**From:** Peter Brocklesby  
**Sent:** 18 October 2021 16:13  
**To:** Alvan Kingston <Alvan.Kingston@wyreforestdc.gov.uk>  
**Subject:** RE: Lodge Farm.

ELEVATIONS AND FLOOR PLAN

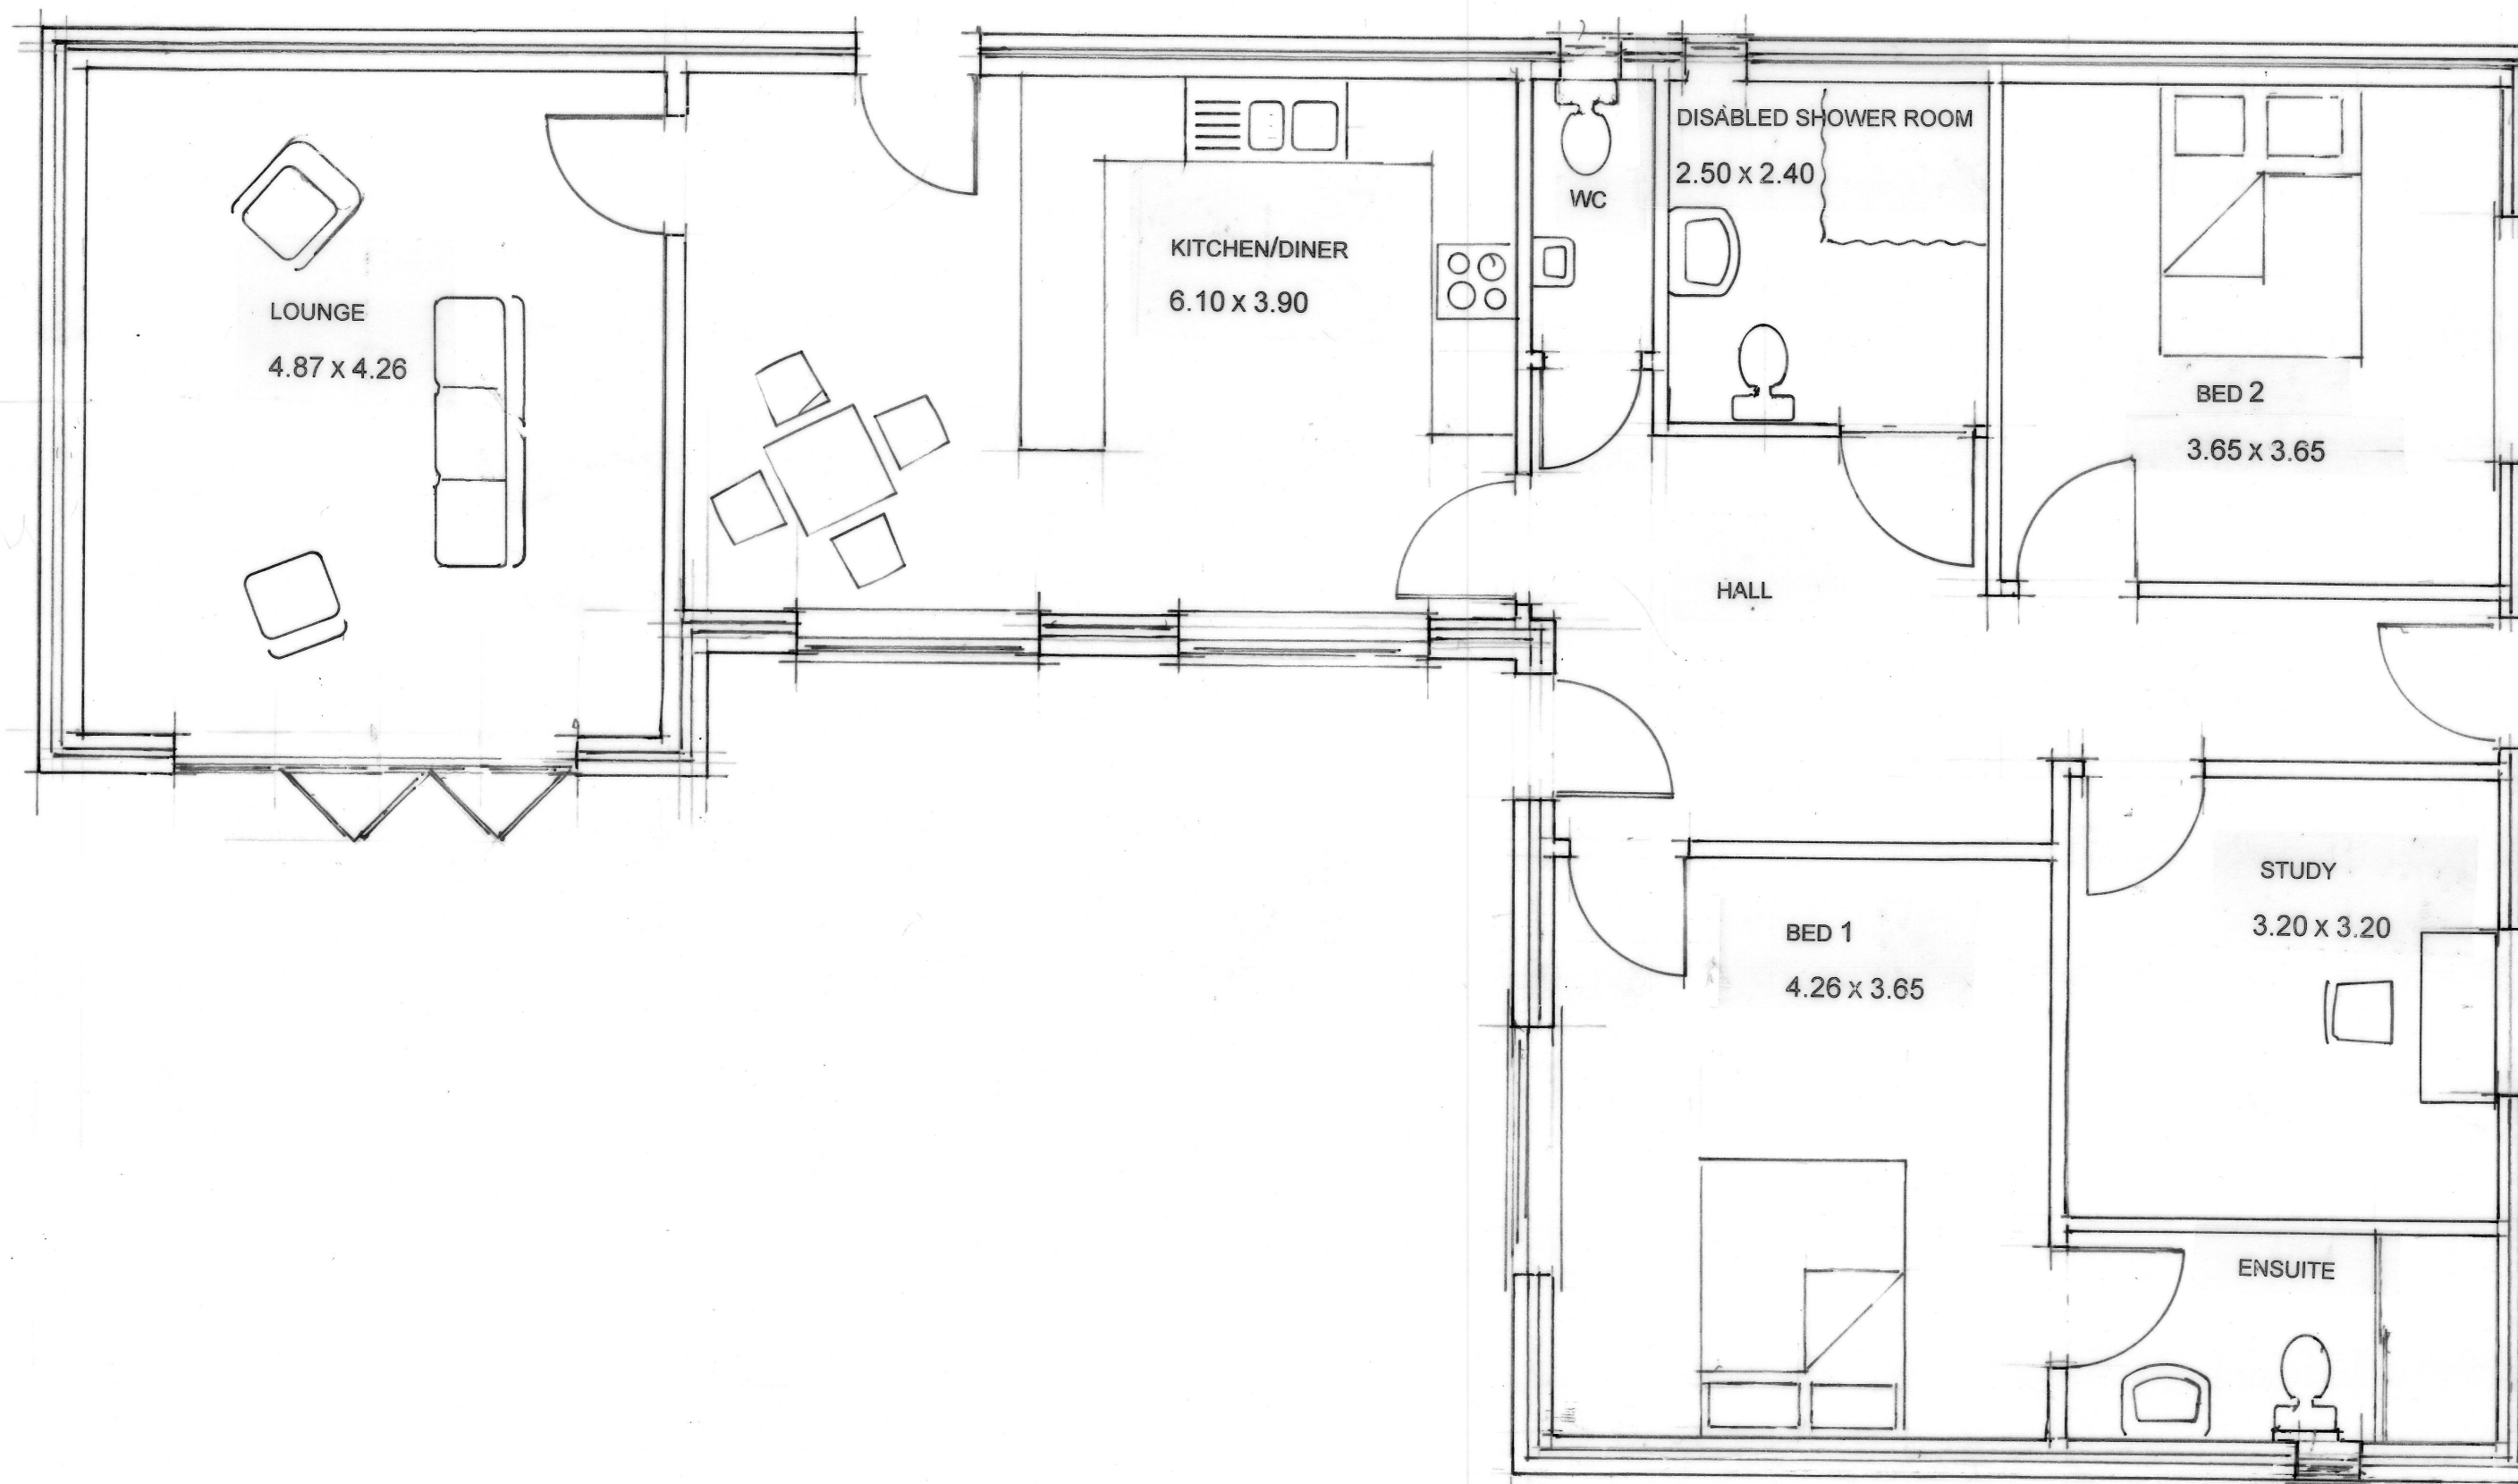
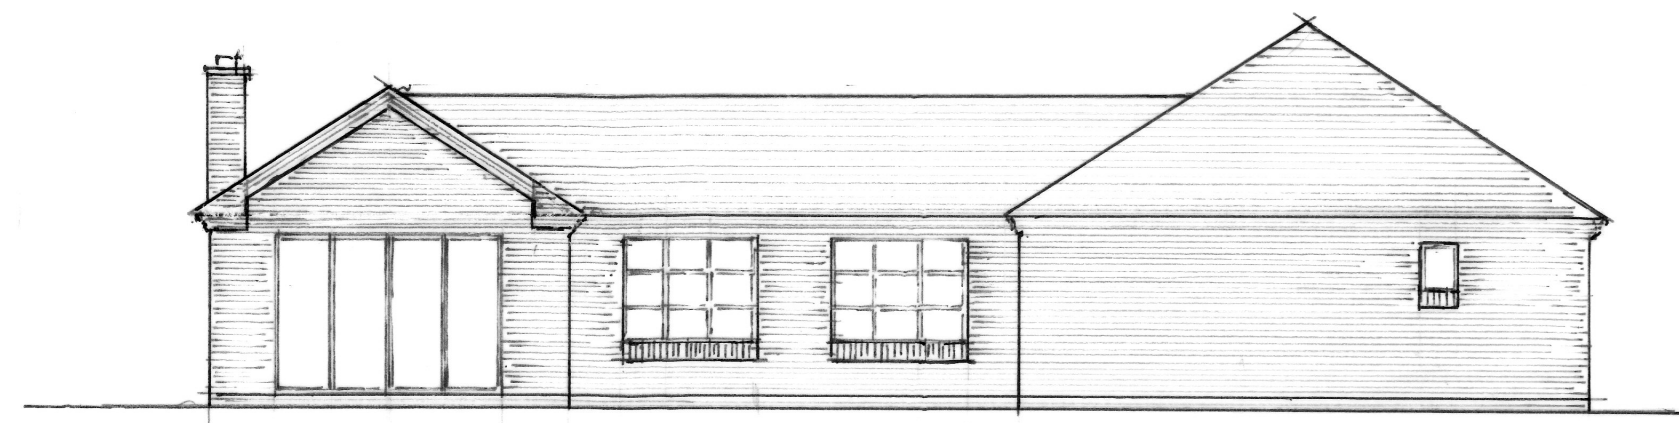
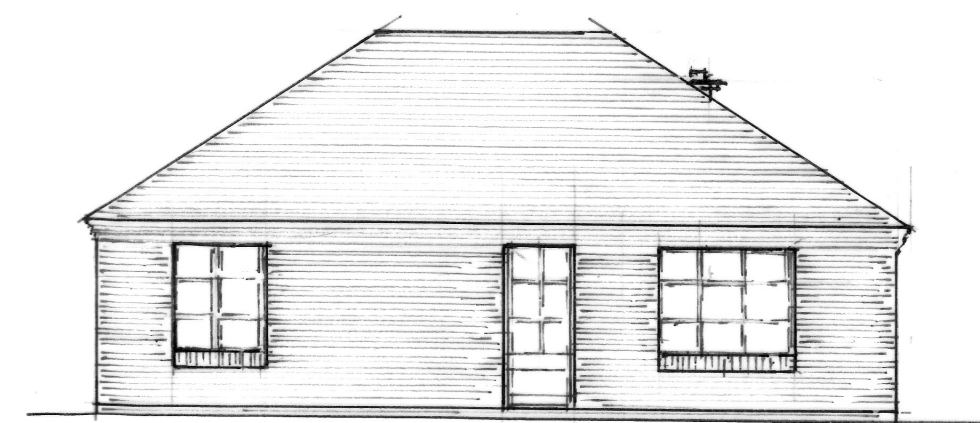
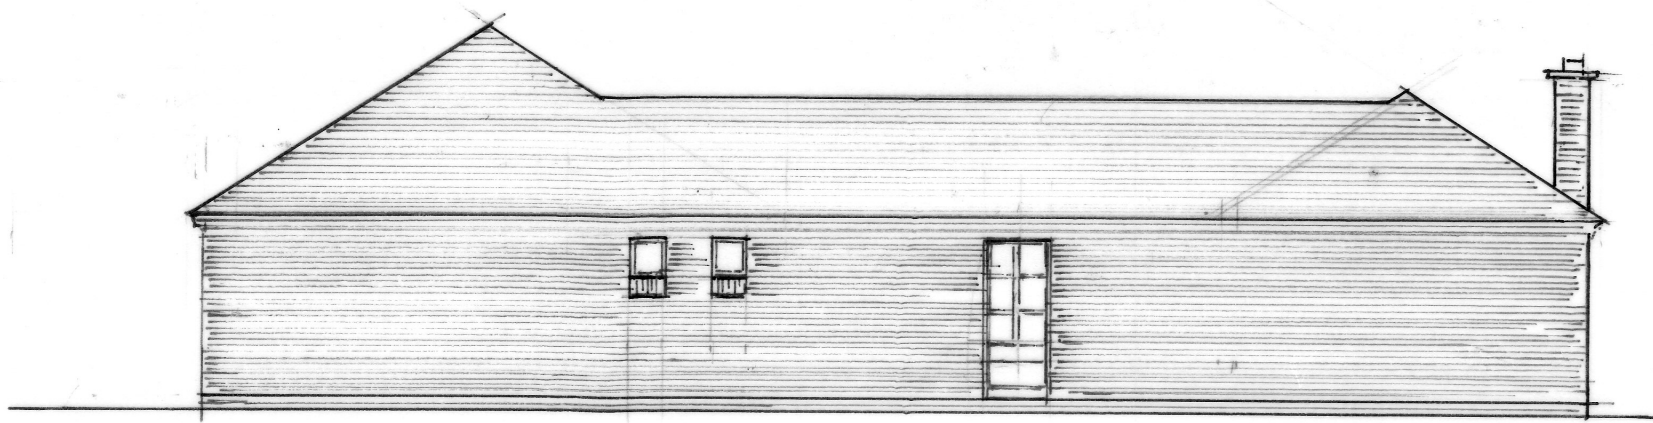
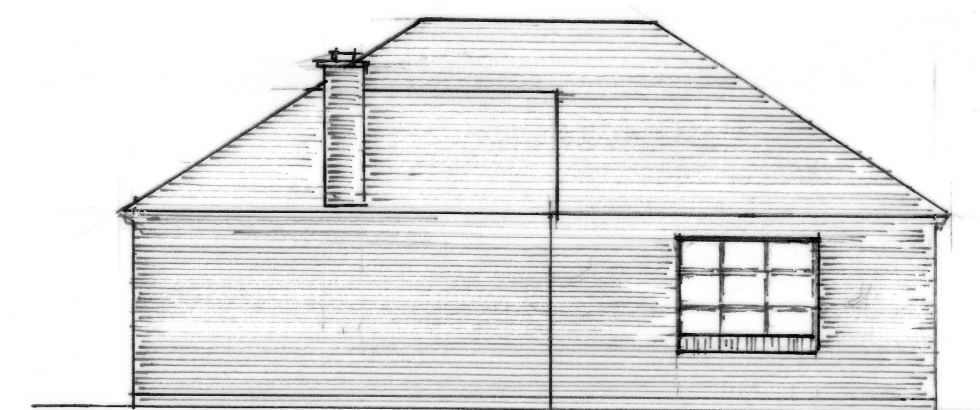
Commenting on the p[oints raised in your email 12<sup>th</sup> October 2021.

1 There is a window to the study 1200mm wide x 1050 high
